Project name	H2Teesside
File reference	EN070009
Status	Final
Author	The Planning Inspectorate
Date	11 March 2024
Meeting with	H2 Teesside Limited
Venue	Microsoft Teams
Meeting objectives	Project Update Meeting including draft document feedback
Circulation	All attendees

H2Teesside – EN070009

Section 51 advice regarding draft application documents submitted by H2 Teesside Limited

DRAWING TITLE
H2Teesside and Net Zero Teesside
Main Site Shared Area Plan

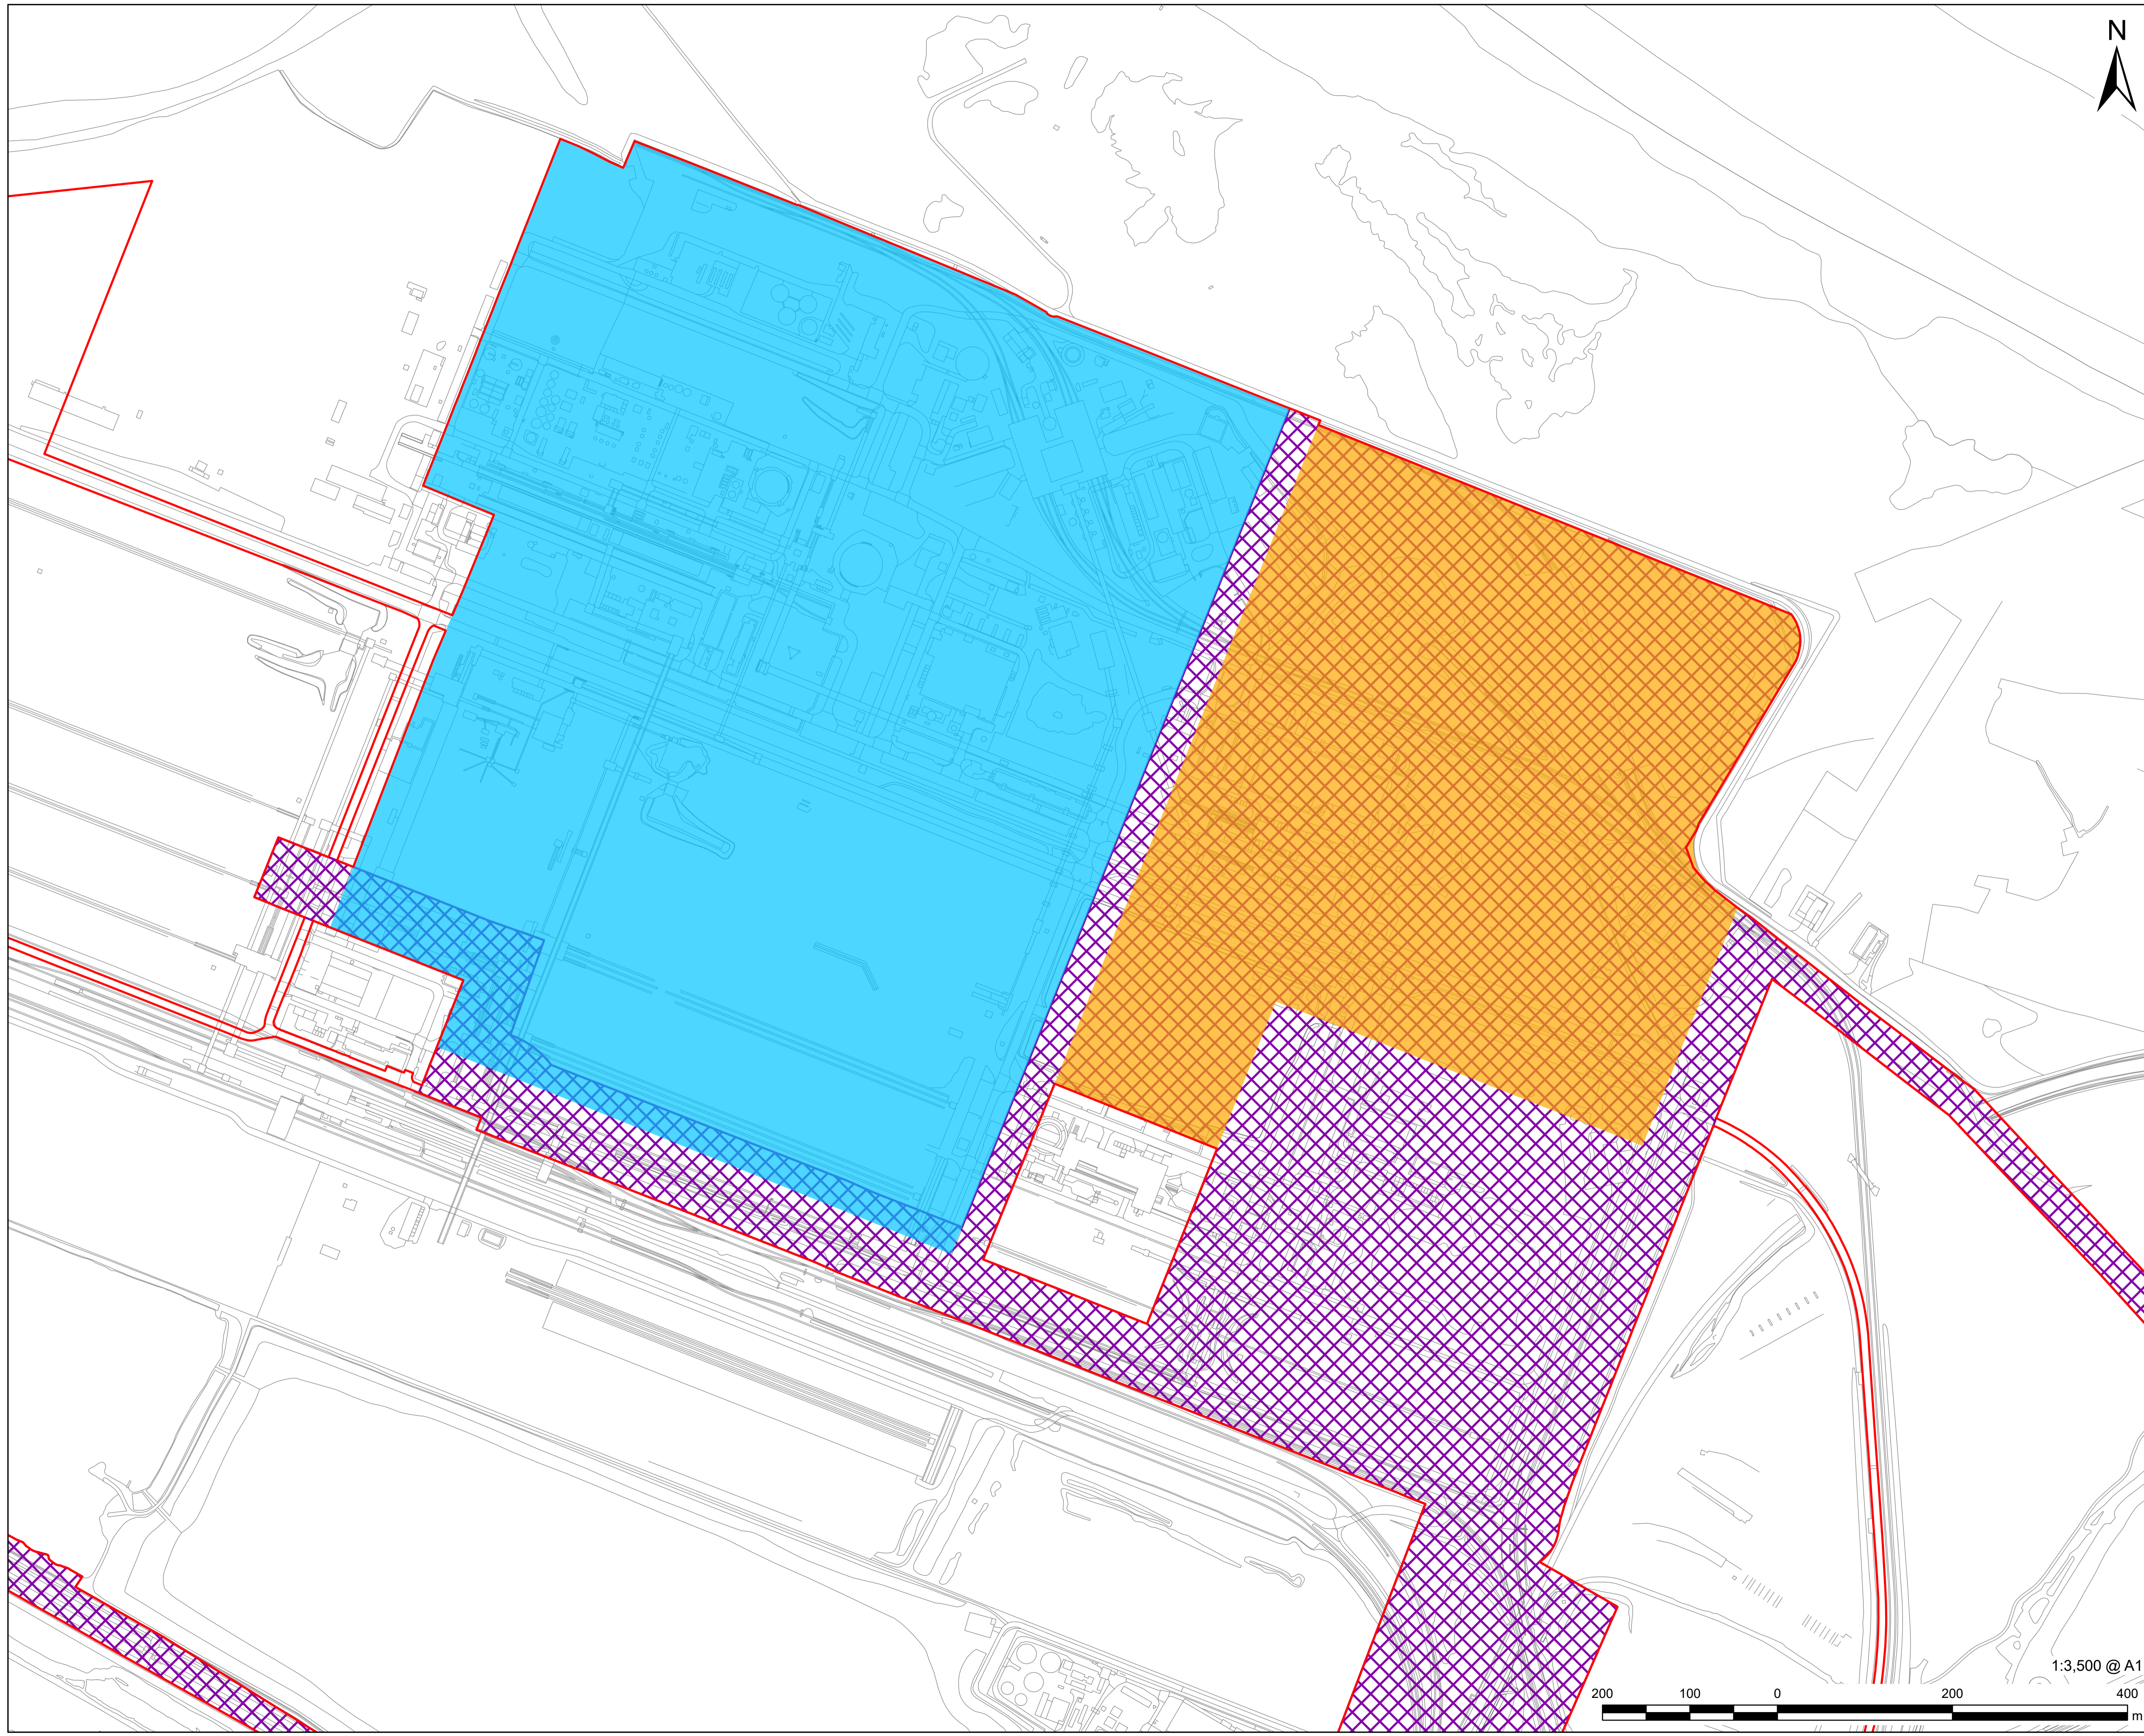
The Inspectorate queried why the proposed Order Limits had changed since environmental impact assessment (EIA) scoping to include more overlap with the NZT main site parts of the application due to the relationship with the NZT project. The Applicant explained that this was following pre-application discussion with the NZT team about powers for some of the proposed shared infrastructure such as the carbon capture export and water connections. The Applicant will provide a plan illustrating the interaction of the two projects.

30.	Plans – general	The Applicant is requested to submit a plan as part of the DCO application that shows the infrastructure proposed in the overlapping areas of the Proposed Development and NZT project, particularly focussing on the area of Work Nos. 1 and 7 in the NZT DCO, which overlap with Work Nos. 3A.2, 4, 5 and 7 of the Proposed Development. The Inspectorate considers that this plan would be essential to understanding how the projects interact with each other.
